**Application by The North Lincolnshire Green Energy Park Limited for North Lincolnshire Green Energy Park  
The Examining Authority's written questions and requests for information (ExQ1)  
Issued on 23 November 2022**

**Responses are due by Deadline 2, Thursday 15 December 2022**

Continues on Sheet 6

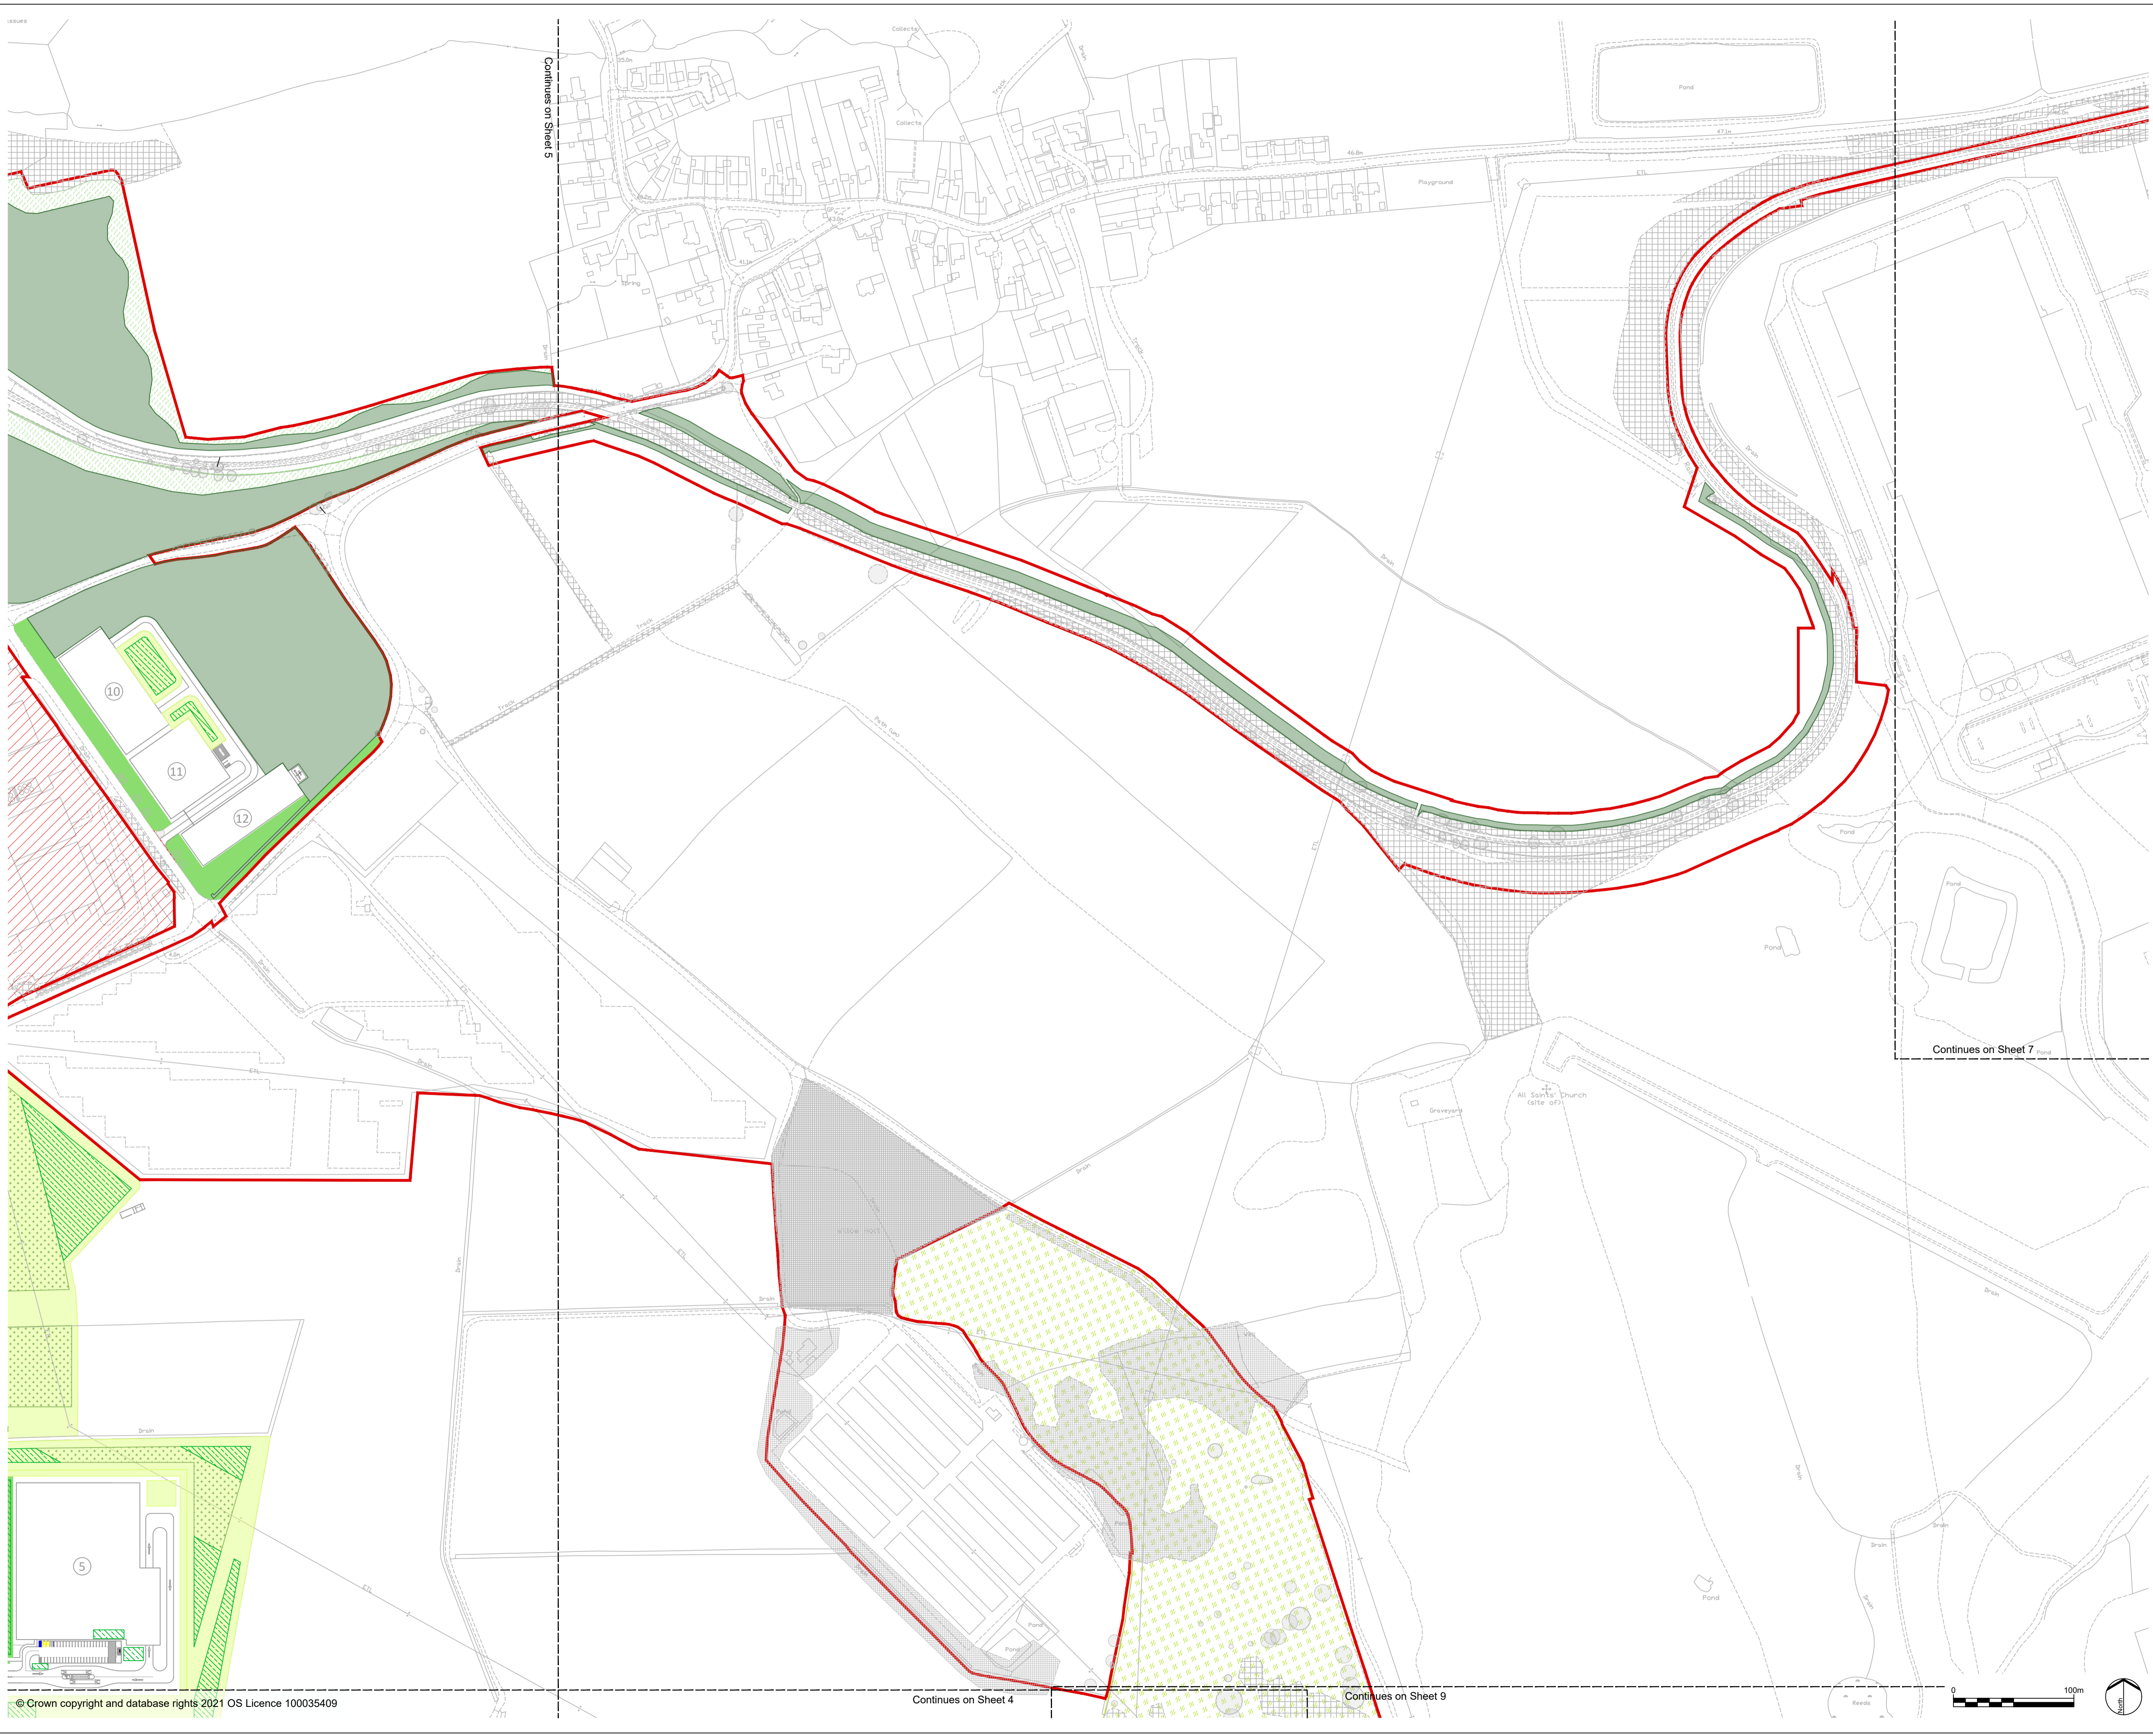
ExQ1	Question to:	Question:
		<p>(i) Can the Applicant confirm what is meant by this term, as the ExA understands from the Outline Landscape and Biodiversity Management and Monitoring Plan (LBMMP) [APP-041] and Indicative Landscape and biodiversity plan [APP-024] that these areas have been set aside for tree planting and an ecological enhancement area.</p>
Q1.0.25	The Applicant	<p><b>Exterior Storage Tanks</b></p> <p>In Chapter 3 [APP-051] at paragraph 3.2.2.25 it states “The facility will also be equipped with a fire water tank, sized to surpass the minimum requirements of NFPA 850”. 7 (National Fire Protection Agency)</p> <p>(i) How is this secured within the DCO?</p> <p>(ii) How much larger than the minimum requirements will this be, in answering this please provide a volume and percentage and a justification for this approach.</p>
Q1.0.26	Applicant	<p><b>Health</b></p> <p>With respect to APP-065 ES Chapter 17 Health</p> <p>(i) Please could the assertions at 6.5, including 6.5.1.5, be amended to provide a clear set of conclusions with the respect to the operation of all the processing plant, including (but not limited to) that required for the incineration of waste and that required for carbon capture plant drawn from the Human Health Risk Assessment presented in Appendix B?</p> <p>(ii) Within Appendix B the final risk assessment values are compared favourably with those ‘conventionally considered to be acceptable for industrial regulation in the UK’ Please could the source be included and explained, or a reference provided within the submissions where this can be found?</p>
